KIRKLEES METROPOLITAN COUNCIL INVESTMENT & REGENERATION SERVICE

DELEGATED DECISION TO DETERMINE PLANNING APPLICATIONS

Reference No:	2023/62/93315/E
Site Address:	71, Heckmondwike Road, Dewsbury Moor, Dewsbury, WF13 3PH
Description:	Erection of two storey side and rear and single storey front extensions
Recommending Officer:	Jennifer Booth

DECISION - REFUSED

PROPOSED GROUND FLOOR

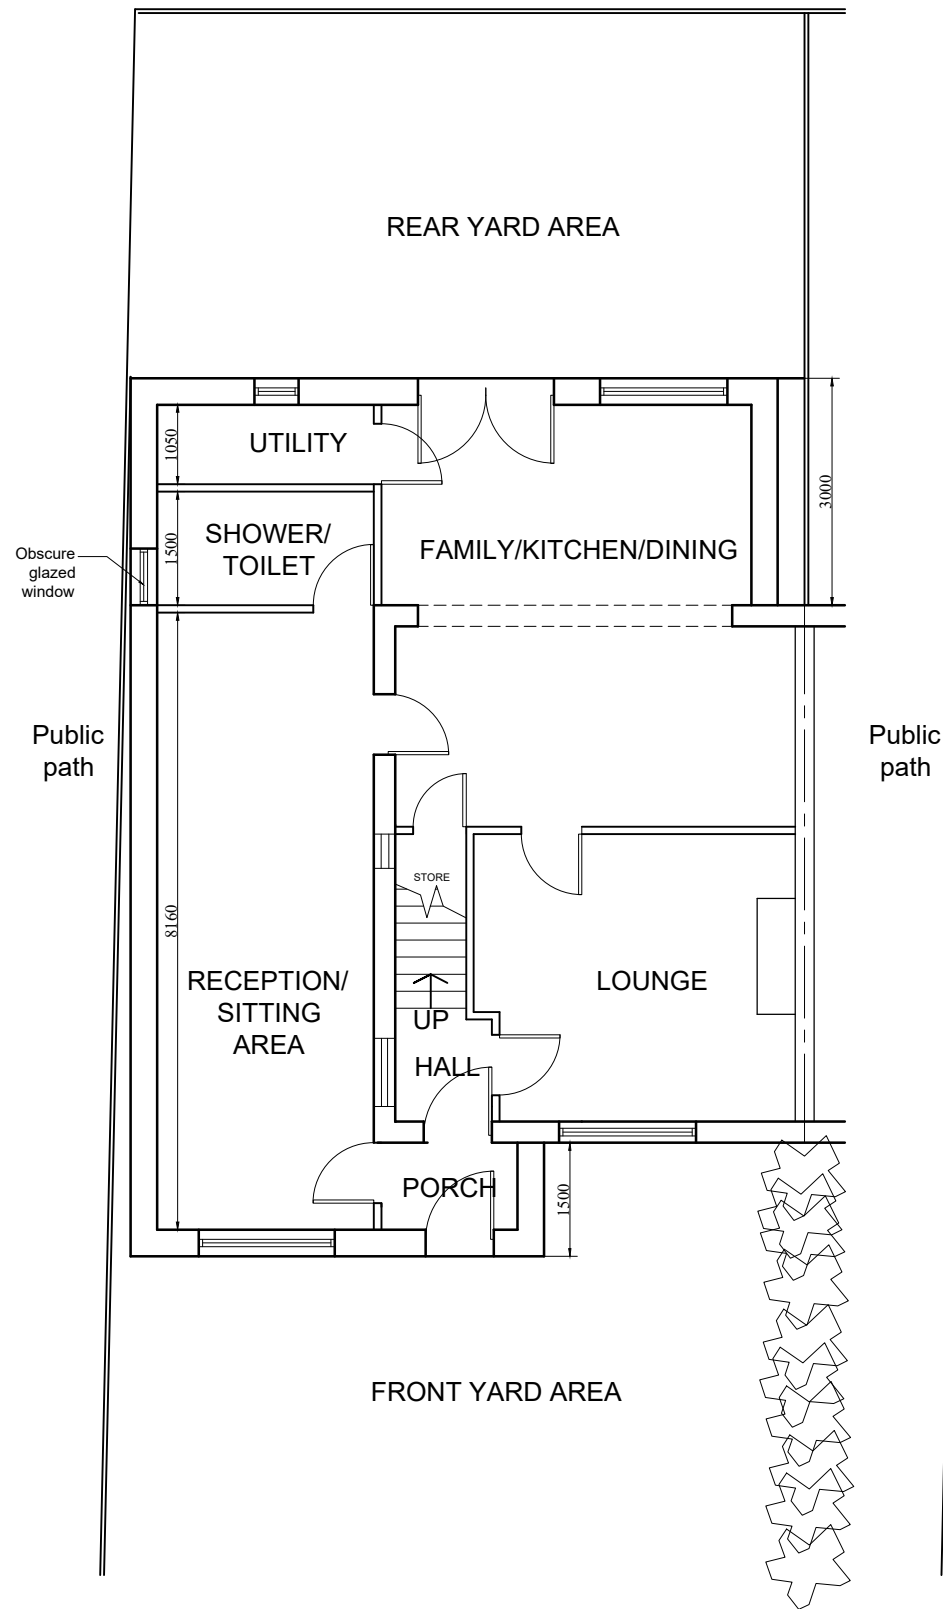
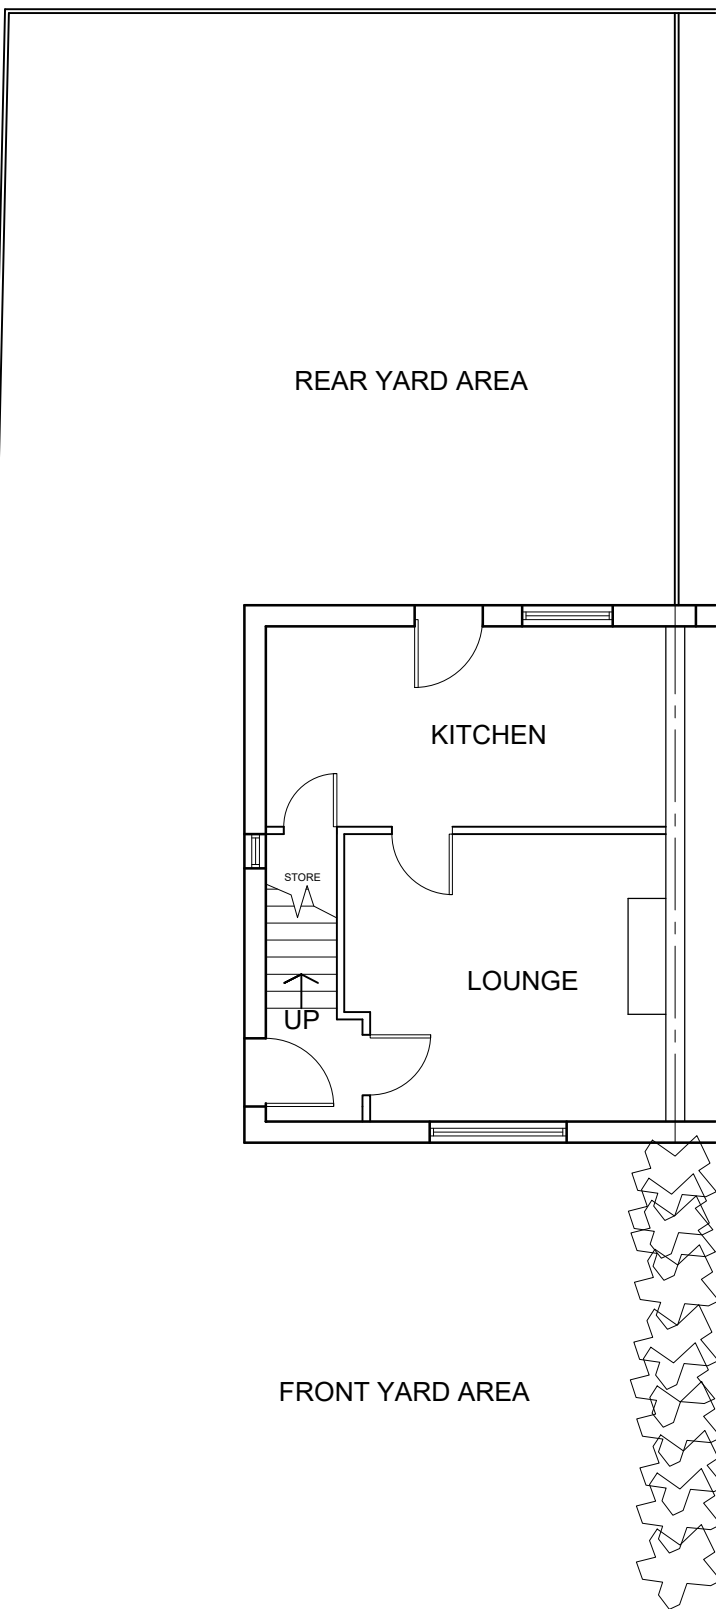
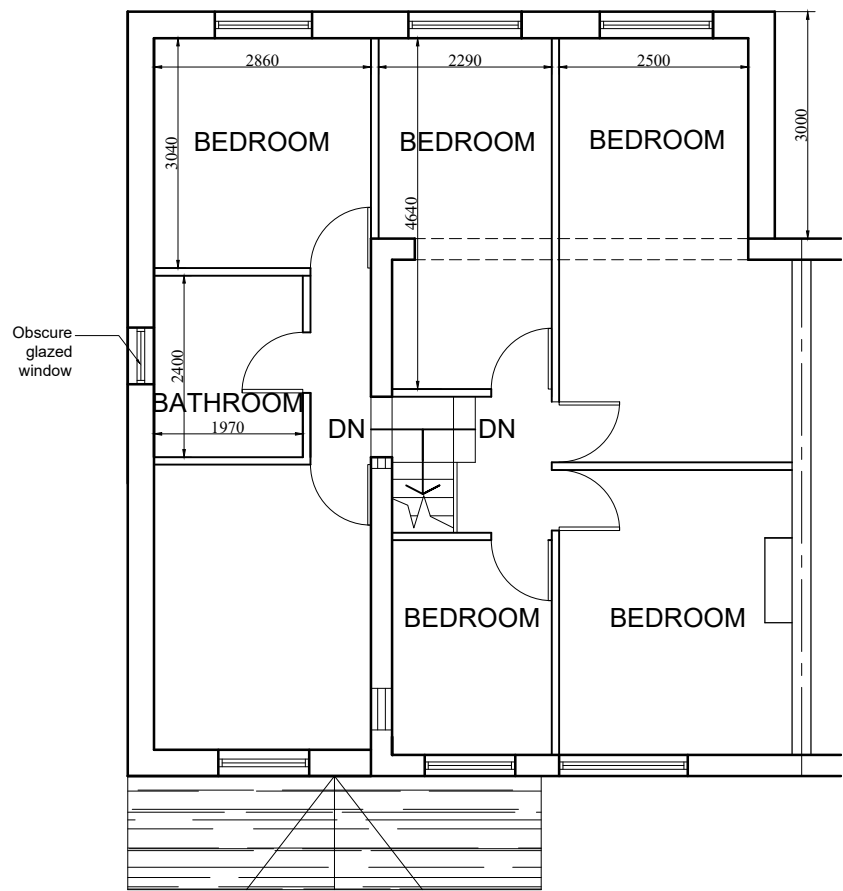
Although the individual elements of the scheme may be considered acceptable in isolation, the host property and its associated curtilage are of a very modest size and, given the level of extensions proposed, would have no meaningful amenity space remaining. As such, the scale is considered not to be acceptable, as it would substantially overdevelop the property and form an incongruous feature, given the limited space remaining around the property.

formed with the side and rear extension would have an overbearing and oppressive impact. Furthermore, the position would result in overshadowing in the late afternoon. It is appreciated that only one window is proposed on the ground floor, which would serve a shower room and, as such, there are no concerns in terms of privacy. However, the bulk and massing would result in such a close and overbearing impact that there would be a significant harmful impact on the amenities of the occupiers of the neighbouring property.

The rear extension would be constructed along the shared boundary. Although it is noted that the projection is limited to 3m, at first floor in particular, this would not comply with paragraph 4.17 of the House Extensions & Alterations SPD given the extent the first floor extension would infringe upon the neighbours first floor window. The position of the extension would result in an overshadowing effect given the position of the extension to the south of the neighbour together with the projection along with an overbearing impact. It is noted that the windows within the extension would not result in any overlooking.

1. The cumulative impact of the varying extensions, given the modest curtilage of the dwelling would result in an incongruous form of the development and insufficient amenity space. To permit the proposals would be contrary to policy LP24 of the KLP, KDP1 & KDP2 of the House Extensions & Alterations SPD and advice within chapter 12 of the National Planning Policy Framework.

2. The proposed rear extension by reason of its projection and position along the shared boundary with the adjoining dwelling would result in overshadowing and overbearing for the first floor windows and amenity space of 73 Heckmondwike Road. To permit the proposals would be contrary to policy LP24 of the KLP, KDP5 & KDP6 of the House Extensions & Alterations SPD and advice within chapter 12 of the National Planning Policy Framework.

3. The proposed side and rear extensions, by reason of the significant bulk and massing, would result in an unacceptable degree of harm in terms of the amenities of the occupiers of the adjacent 69 Heckmondwike Road, with regards to overshadowing in the afternoon and an overbearing impact. To permit the proposals would be contrary to policy LP24 of the KLP, KDP5 & KDP6 of the House Extensions & Alterations SPD and advice within chapter 12 of the National Planning Policy Framework.
